Project Name : Bilsham Road, Yapton
Job No : 19-326
Note Title : Drainage Strategy and MMP
Author : NA
Checked : GG
Approved : GG
Date : November 2020

1.1 Odyssey has been commissioned by Bilsham Road Development LLP to undertake a surface water and foul drainage strategy as part of a reserved matters application associated with the proposed residential development at Bilsham Road, Yapton.

P:19-326 - Bilsham Road, Yapton RMT Technical Drawings 000 Series 19-326-010 Preliminary Engineering Layout Sheet 2 of 2.dwg

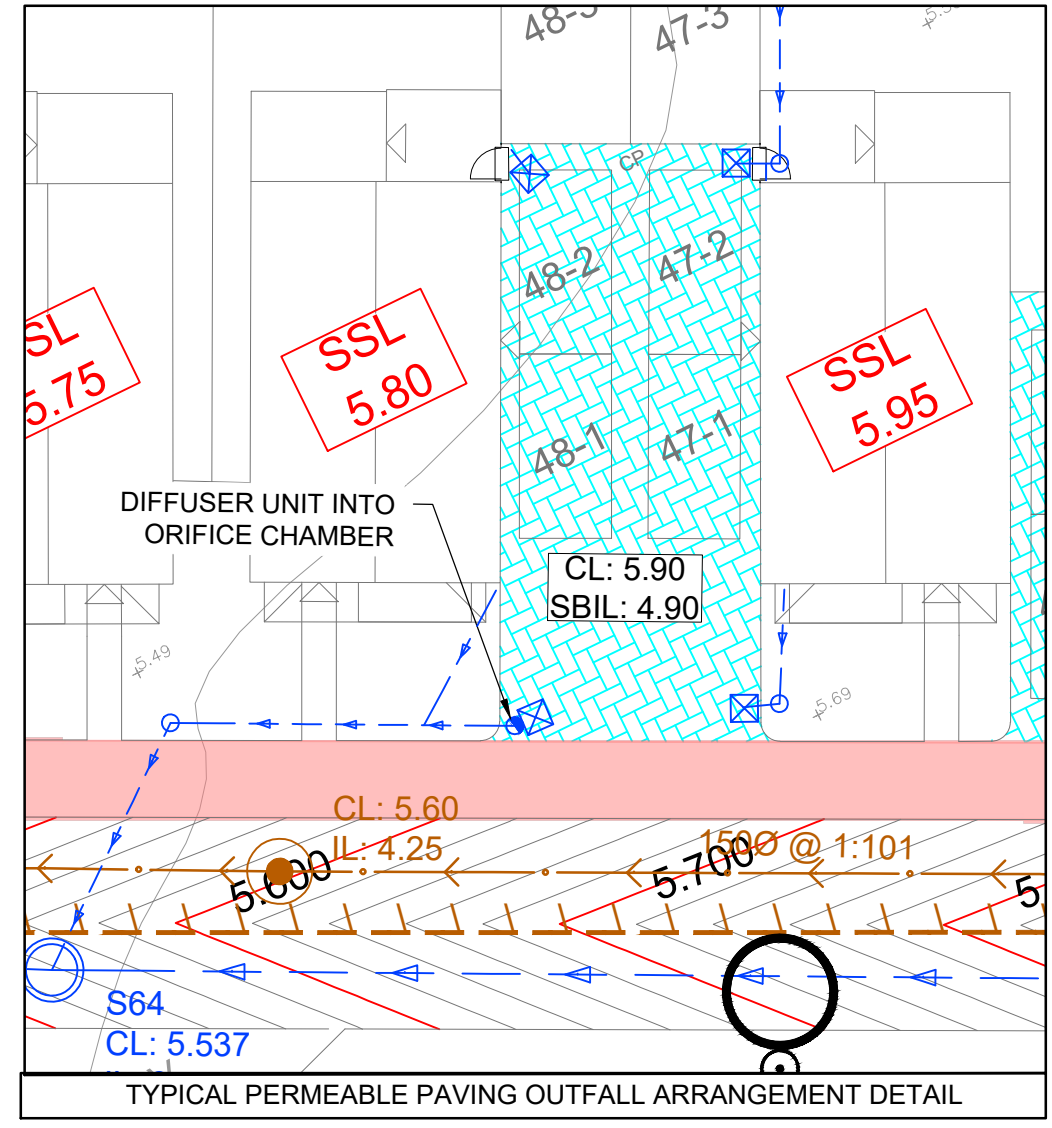
2.8 Initial comments were received from the Principal Drainage Engineer at Arun District Council. A response to these comments can be found below.

1. The permeable paving has been extended to all parking spaces/property driveways
2. All basins have been designed with at least 300mm freeboard
3. To be checked at detailed design
4. Basin 4 has been kept in its previous position. To move this any closer would result in a clash with the flood plain.
5. To be checked at detailed design.

6. Only minimal flooding of 2.8m³ is registered in two manholes. Overland flow routes ensure the excess surface water is kept away from people and property.
7. Typo in section 2.5 of report has been updated.
